Your ref: SSD-76555711
Our ref: DOC25/501541

Subject: Major Projects - Response to Submissions (RTS) - Mixed use with infill affordable housing (SSD-76555711) (Willoughby City)

Thank you for your email dated 23 September 2025 seeking advice from the Conservation Programs, Heritage and Regulation (CPHR) group of the NSW Department of Climate Change, Energy, the Environment and Water (DCCEEW) on the State significant development application (SSD-76555711) located at 3-5 Help Street, Chatswood.

Flood Risk Assessment

LGA: WILLOUGHBY

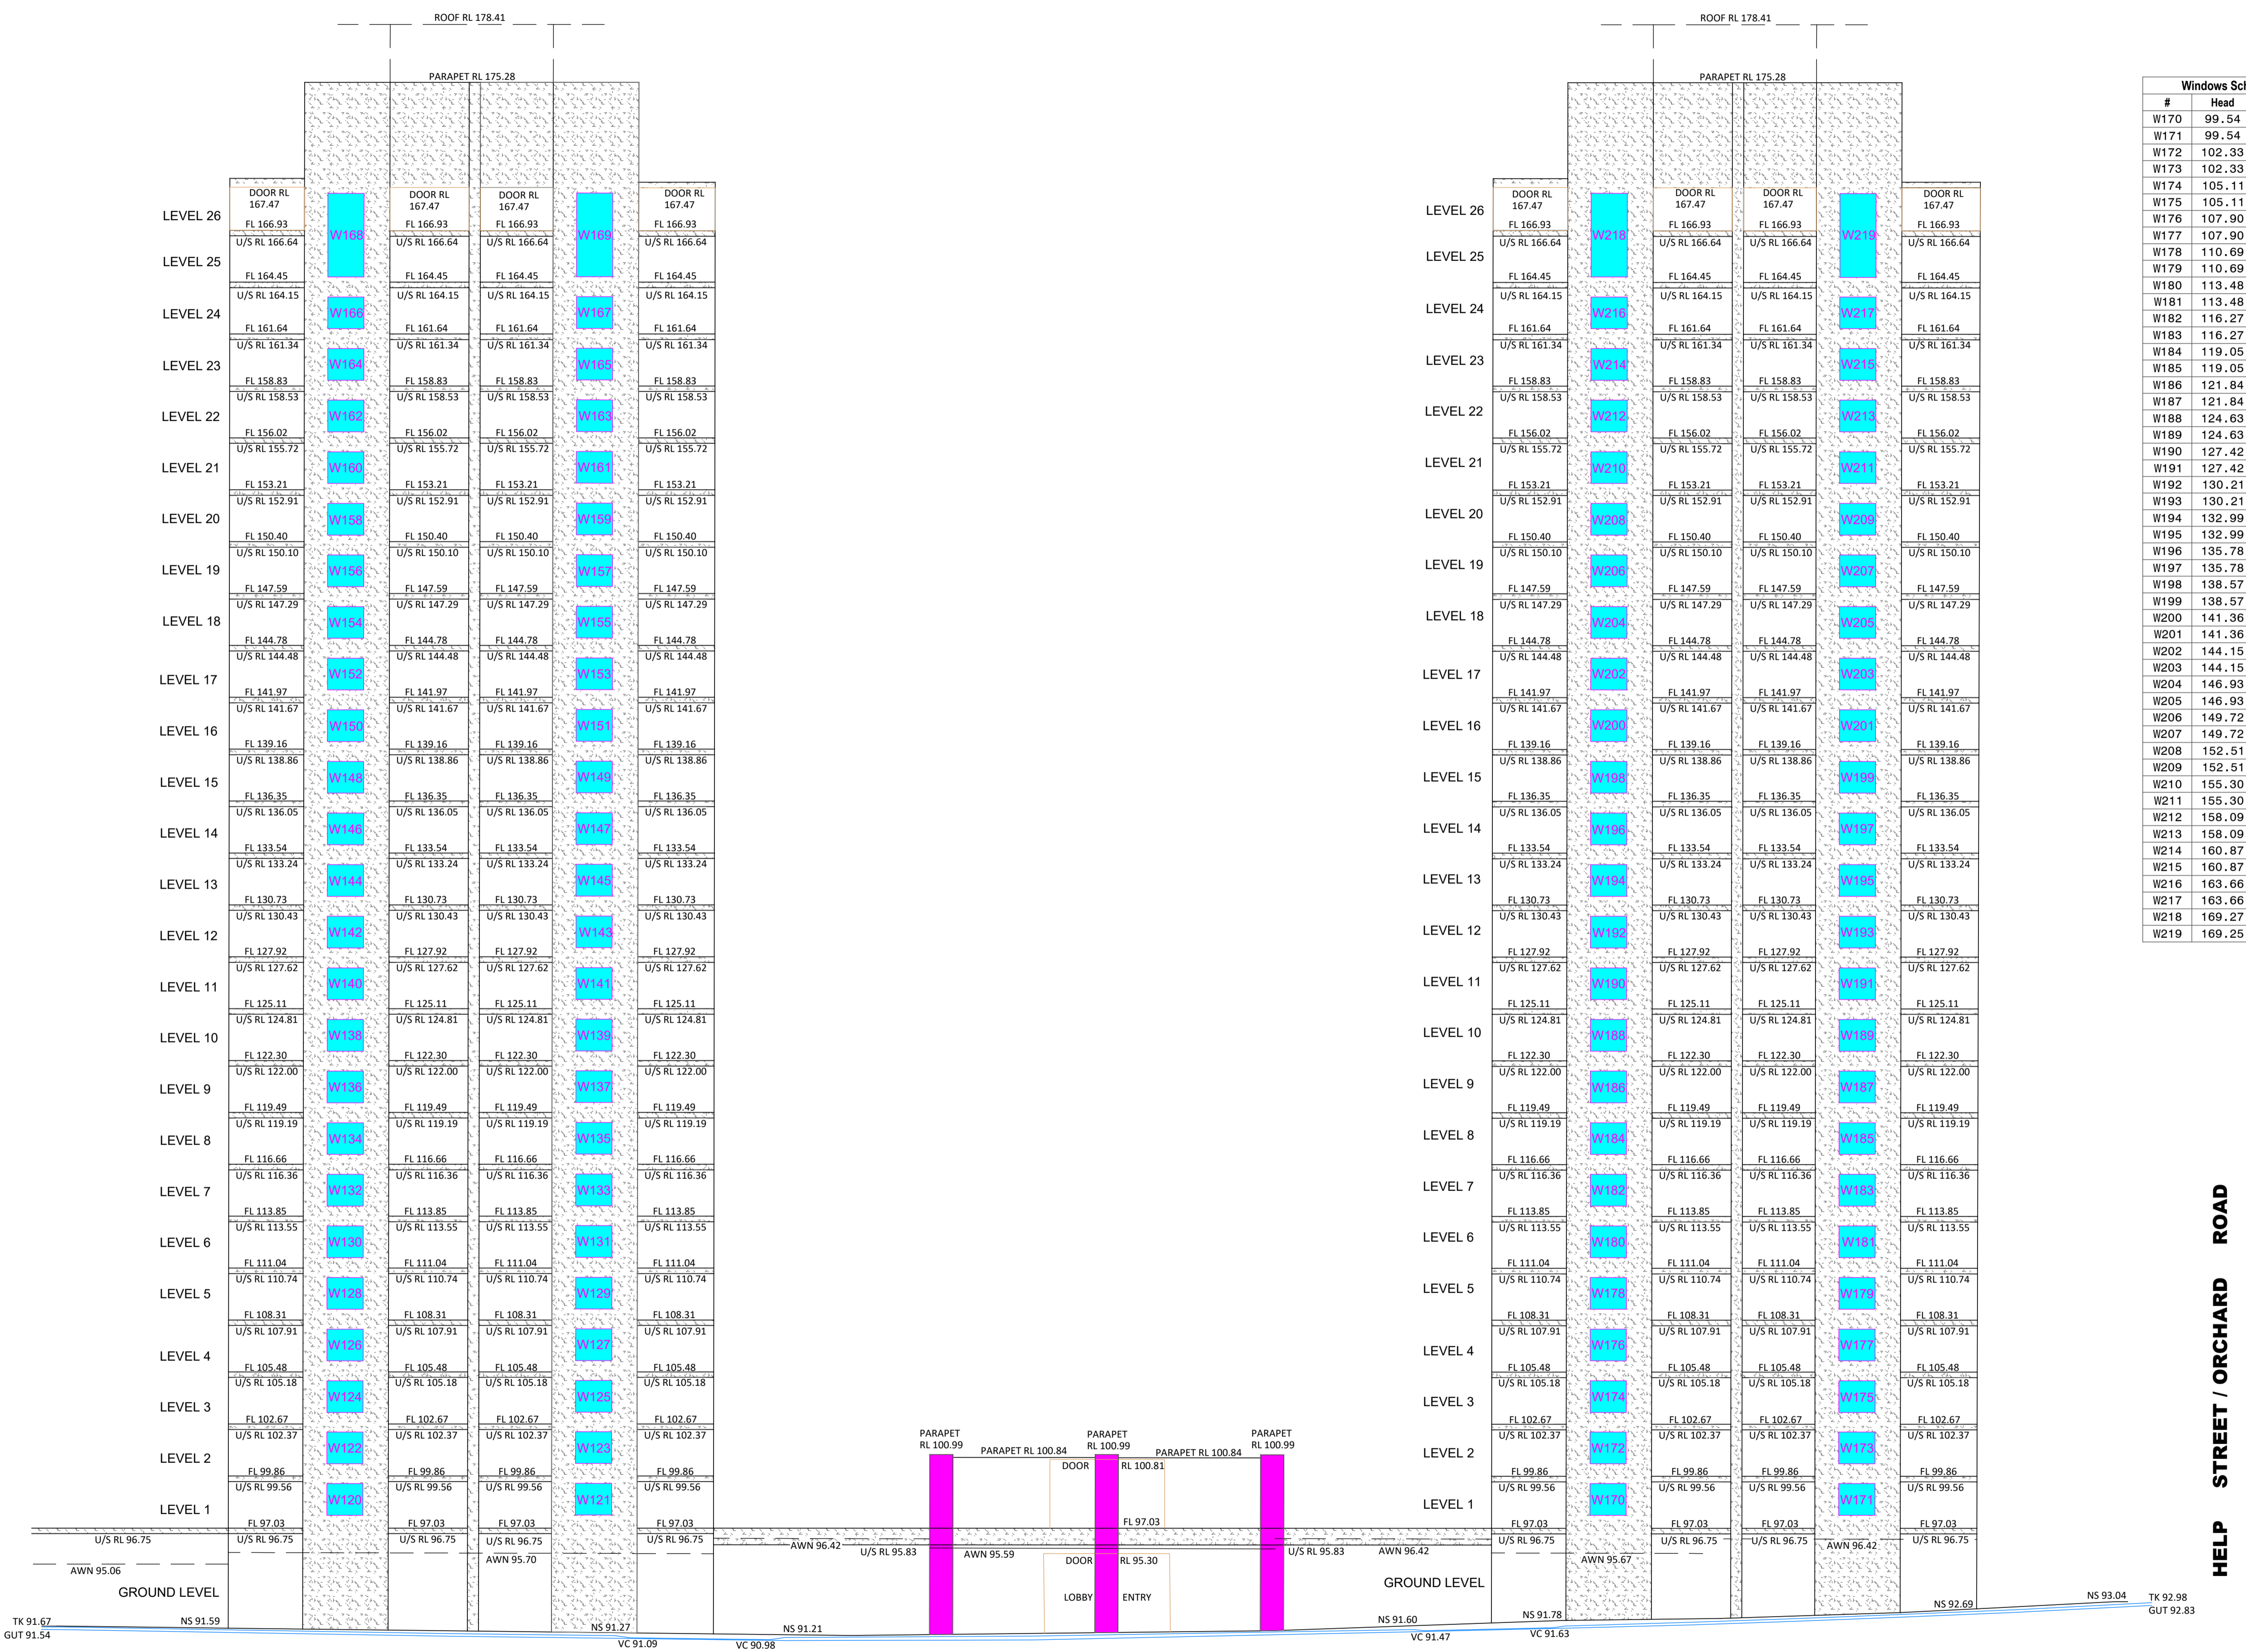
The flood report previously provided by Stantec estimated a PMF level of 93.54m AHD in the sag point in Help Street. If the water was able to escape via the Anderson Street corner, then the flood report should have been able to confirm this by modelling. The survey in the civil drawing set does not show levels for the full extent of Help Street however levels of at least 91.8m are shown in the truncated survey and this is higher than the 91.6m reported by the flood consultant. CPHR does not agree with these assurances made in the RTS.
